WEST SUSSEX COUNTY COUNCIL CONSULTATION

TO:	Arun District Council FAO: Andrew Wood
FROM:	Highways, WSCC – Matthew Bartle
DATE:	8 May 2018
LOCATION:	Bradlaw House, 5 Sudley Road, Bognor Regis, PO21 1EJ
SUBJECT:	BR/52/18/PL Change of use from mixed use development consisting of Dental Surgery (D1 Non-Residential Institutions), night club (Sui Generis) & part residential (2 No. units existing) (C3 Dwellinghouse) to conversion to 8 No. flats with associated services (6 No. new units). This application may affect the setting of a listed building.
RECOMMENDATION:	☒ Advice ☐ Objection ☐ Modification ☐ No Objection ☐ More Information ☐ Refusal
S106 CONTRIBUTION TOTAL:	£ to follow See below for breakdown.

Site Plan 1:500
0 5 10 M

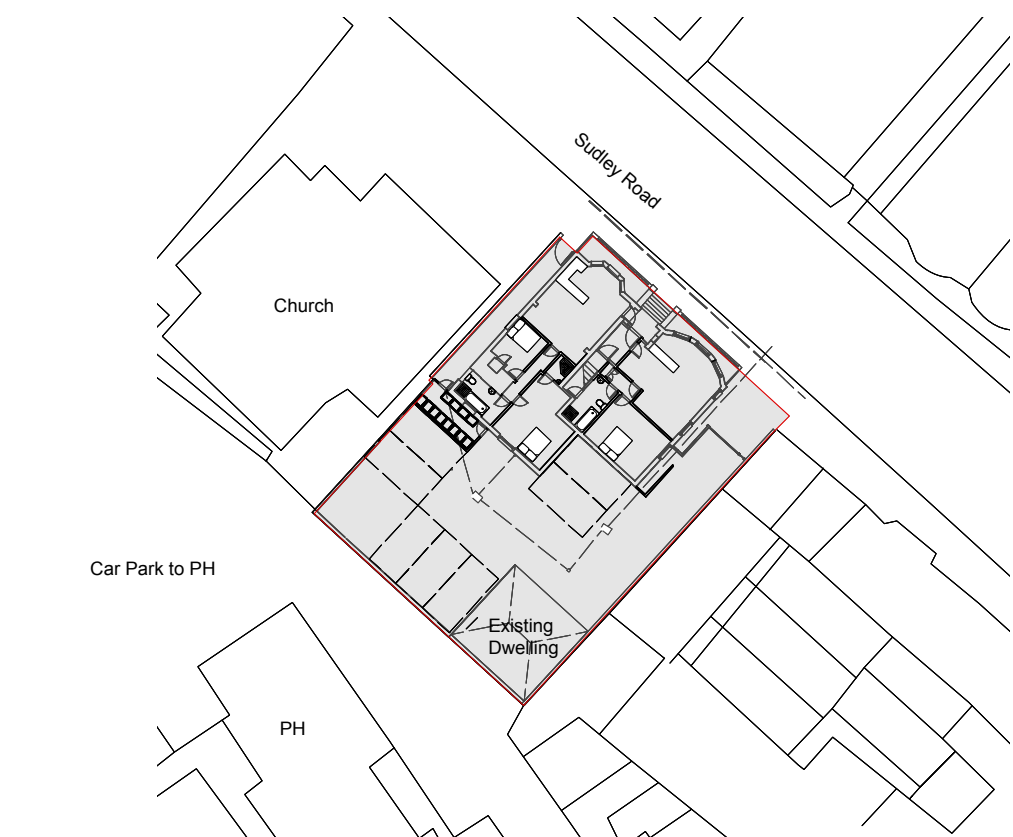
- the entrance through the gate from Sudley Road is 2.6m wide and the 3.2m width of the rest of the entrance-way does not give room for two vehicles to pass
- the room for manoeuvre round the car parking spaces is very restricted
- it is not clear how the occupier of the existing home at the rear of the site will get to their property
- the refuse bins are in a very restricted place behind the main building and there may be a tendency for residents not to want to cart them to the front
- there is no sign of a lift or shallow stairway between floors. How would residents get their furniture in and out and how would people in a wheelchair or with a baby buggy get from floor to floor?
